Your ref: 3/2022/0683 and 0684

Date: 18<sup>th</sup> August 2022

**Applications 3/2022/0683 and 0684: Reconfiguration and restoration of an existing listed property and work to an existing outbuilding within the curtilage to be used as an annex.**  
**Knott Gate, Townend, Slaidburn BB7 3EP**

Proposed South East Elevation
Scale: 1:100

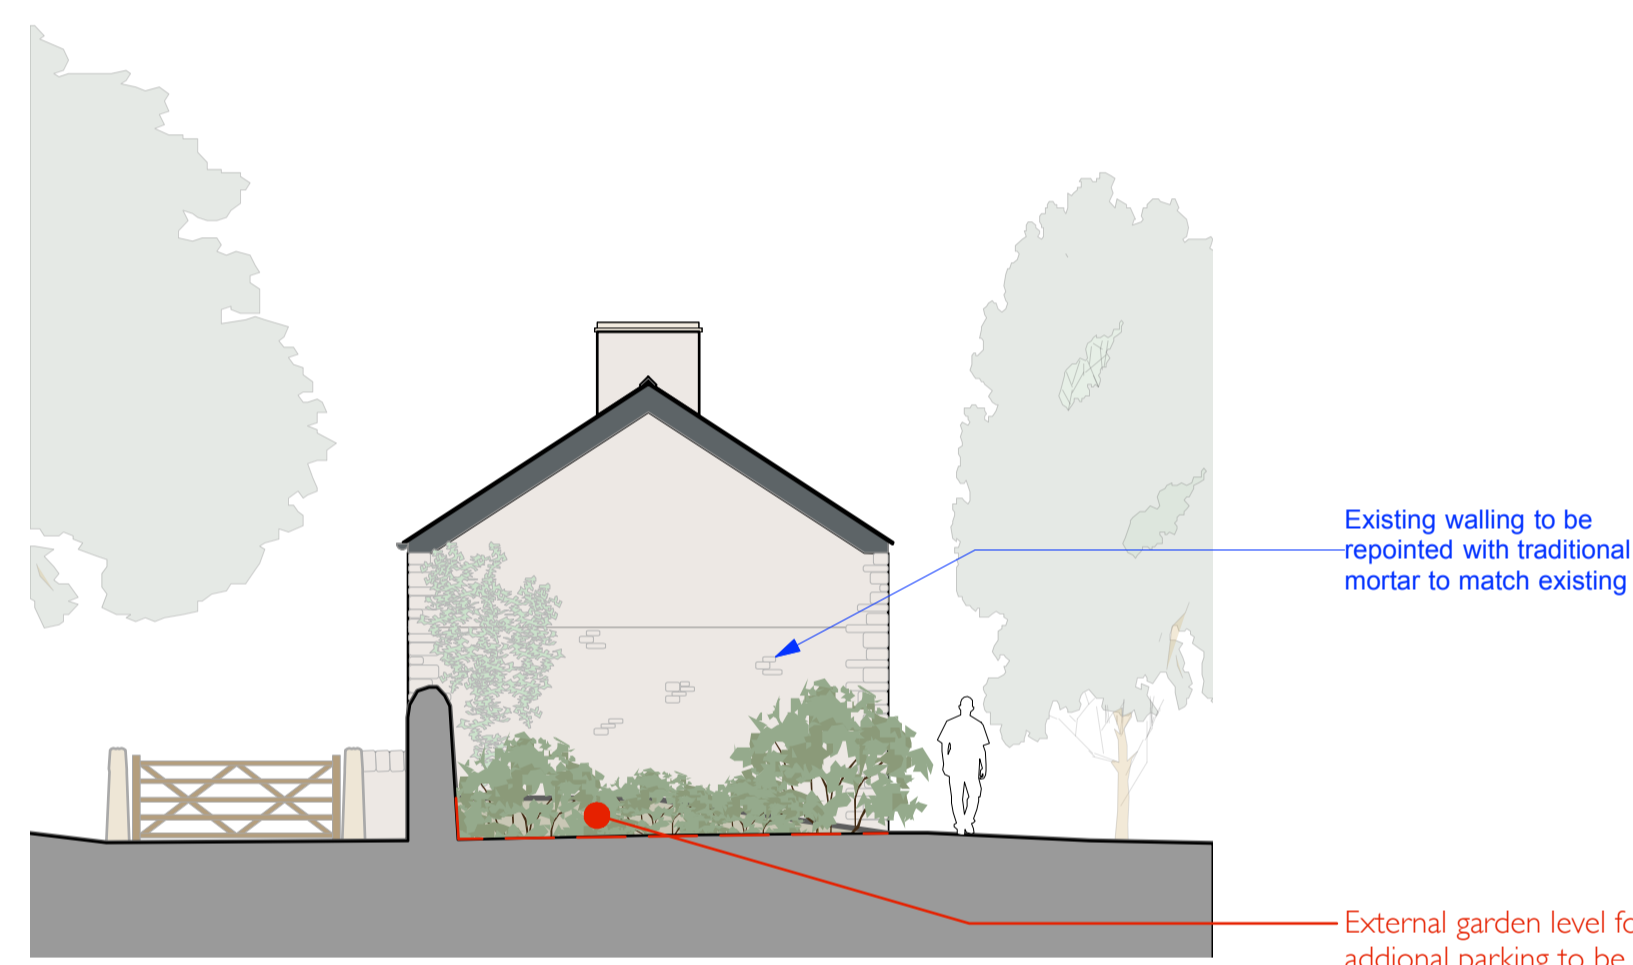
Items p and q impact the external stone steps on the garden front of the building. The HS notes that the steps are in 'very poor condition', but this is not supported by evidence of a condition survey or appropriate photographs. Because of the way that the stair is cantilevered out of the walling dismantling and reconstruction or repair will not be a simple task and we would suggest that further information on the present state of the stair is required, along with details of the rebuilding work proposed. A method statement for the repair or rebuilding (if found to be appropriate) and the detailed design of the proposed new railing and balustrade will need to be agreed with the council.

○ **Outbuilding Proposed West Elevation**
 Scale: 1:100
 Ancillary Accommodation

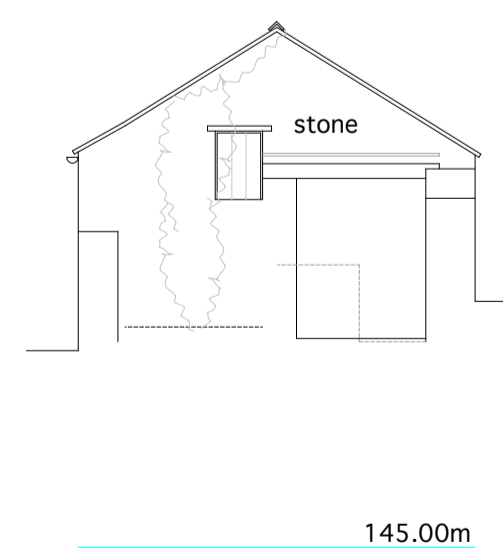
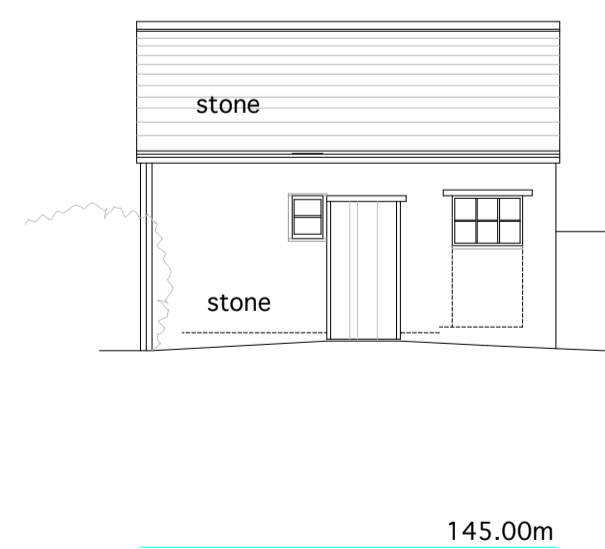
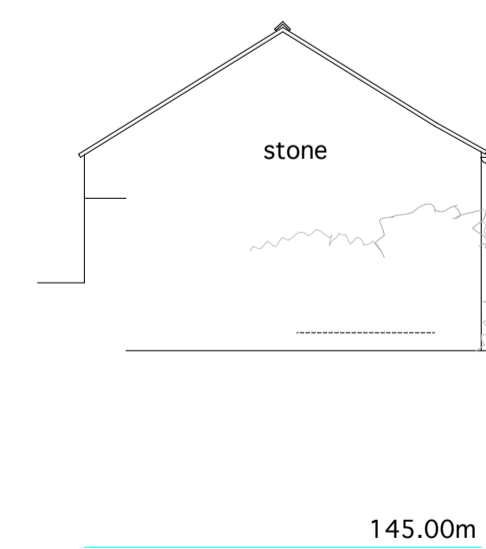
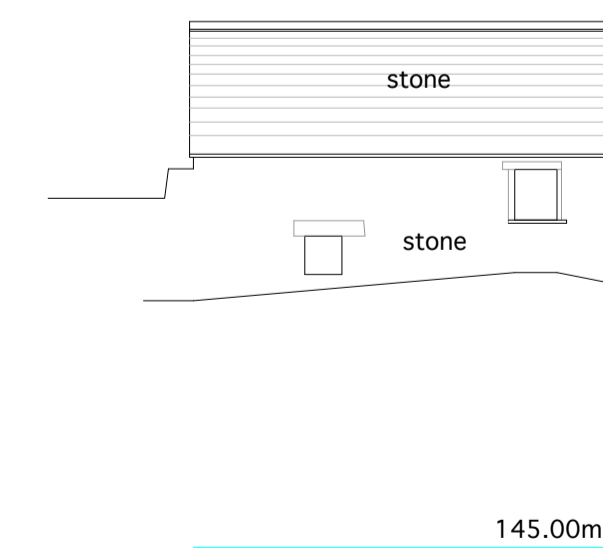
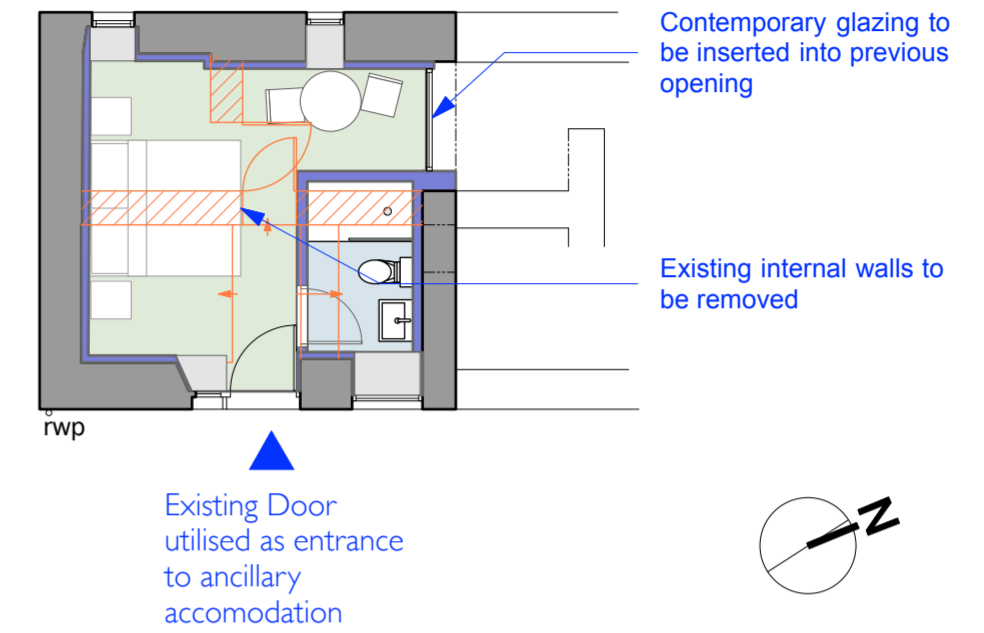
The proposed re-roofing of the ancillary building (item s) is mentioned above, as is the fact that this roof is described as 'stone' and not slate on the plans 'as existing' and in the Bat Survey. Indeed, in Appendix 5 of the HS the roof is described as '*One of few flag roofs in the Conservation Area*' and '*Has a strong vernacular character*'. It is also stated there that it is likely the earliest roof on site and '*Probably 18C or even 17C*'. Impacts would thus seem to be on the higher end of 'medium' or even 'major' rather than 'minor or negligible'. It would seem appropriate for this roof to be retained and repaired in its present form, if possible. As above it is noted that there is no condition survey of this roof or details of the work proposed. What repair work is required to the roof covering? Are there surviving historic timbers and do any require repair or replacement? Is it intended to insert any underfelt or insulation into this roof as part of the conversion to residential use? Much more detail on the need for this work, what is proposed and a strong justification for any changes should be provided on this aspect of the scheme before it is agreed.

Item (t) also appears to have a more significant impact than that set out in the HS. The complete removal of the '*likely original*' wall of '*probably 18C or even 17C*' date would appear to remove much of the evidence for the origin and use of the building, as would the removal of the present internal fixtures and fabric (item u). The totality of what is proposed would seem to retain only the original external walling, with the roof, floors and internal plan all being swept away. Items v and w would have lesser impacts, although no doubt some repair, adaption, and alteration of the exterior door (and other exterior openings) will be necessary, and further details of these changes will be required at some stage. Whilst the creation of a new use for this outbuilding would help ensure that it is maintained and retained, the impact of the present proposals is at least higher 'medium' if not cumulatively 'major' adverse, yet little if any justification is provided. A
